Application for a non-material amendment following a grant of planning permission.

EP/27/10/NMA

DEMOLITION OF EXISTING BUILDINGS AND ERECT 21 NO. NEW DWELLINGS, ACCESS, PARKING & PROVISION OF PUBLIC OPEN SPACE AT FORMER REDUNDANT NURSERY SITE.

EP/95/08

SOUTH ELEVATION

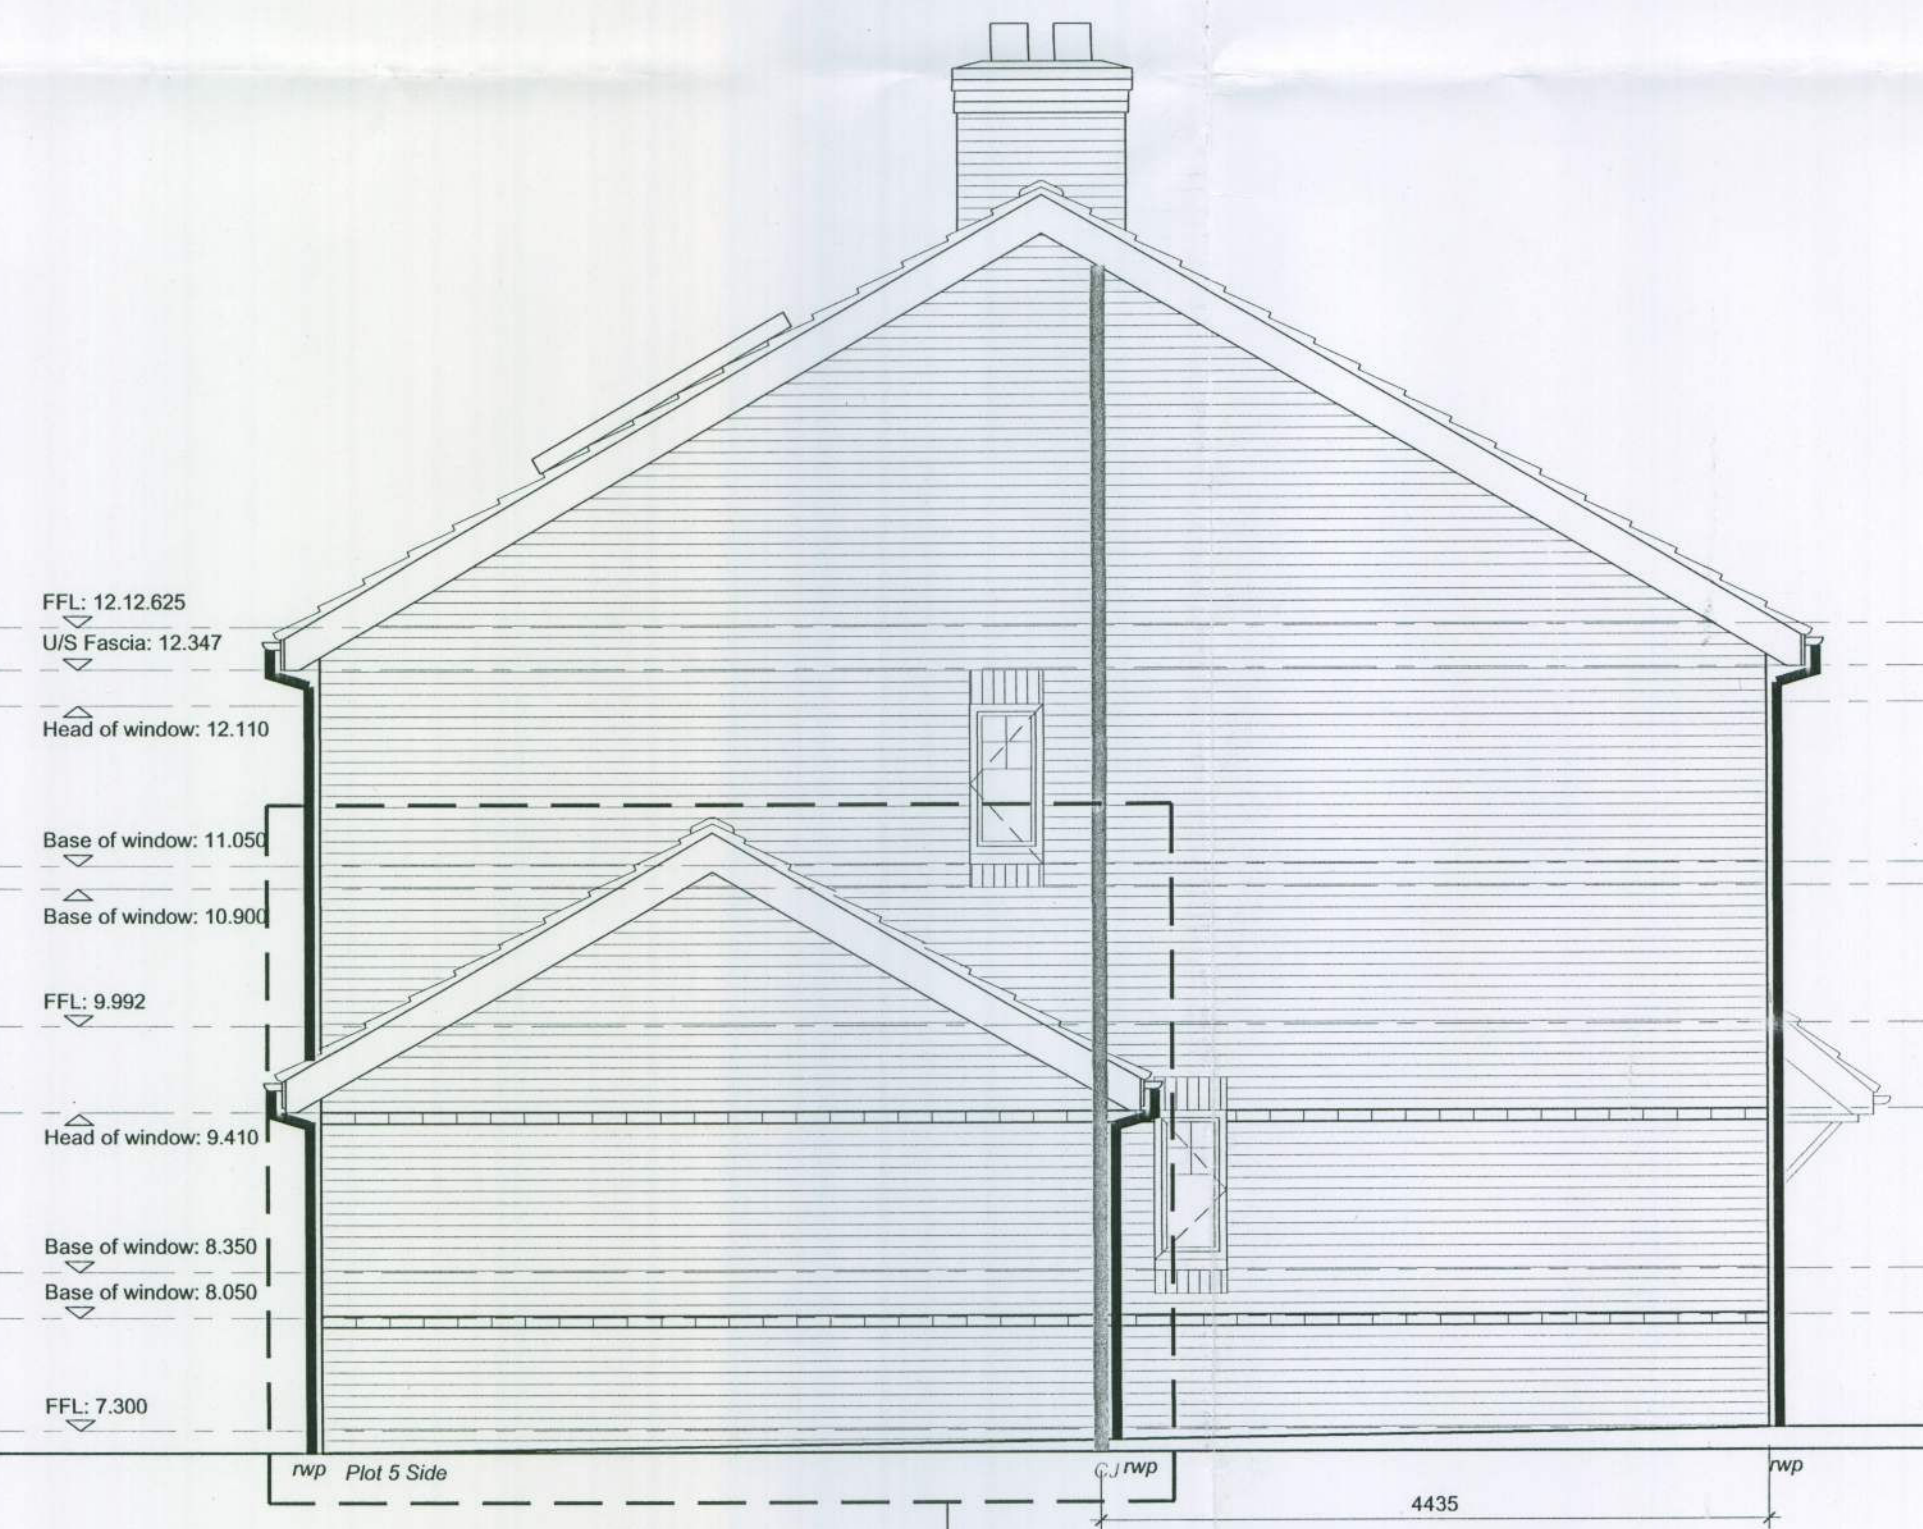
1. TO OMIT THE GALLOWS BRACKETS SHOWN ON THE EAST ELEVATION AT FIRST FLOOR BOTH SIDES OF THE GABLE WINDOW
2. TO REVISE THE CHIMNEY DESIGN FROM THOSE SHOWN ON THE APPROVED DRAWINGS TO THOSE INDICATED ON OUR PROPOSED CONSTRUCTION DRAWINGS.

1. THE GALLOWS BRACKETS ARE CURRENTLY DETAILED AS BACKING ONTO TILE HANGING, IT WILL BE VERY DIFFICULT TO INSTALL THESE GALLOWS BRACKET WITH TILE HANGING FINISHING NEATLY INTO BOTH SIDES OF THE BRACKET.
2. WE WISH TO VARY THE DESIGN OF THE CHIMNEYS ON THE APPROVED PLANNING DRAWING & INSTEAD CONSTRUCT THE CHIMNEYS AS DETAILED ON OUR CONSTRUCTION DRAWING.
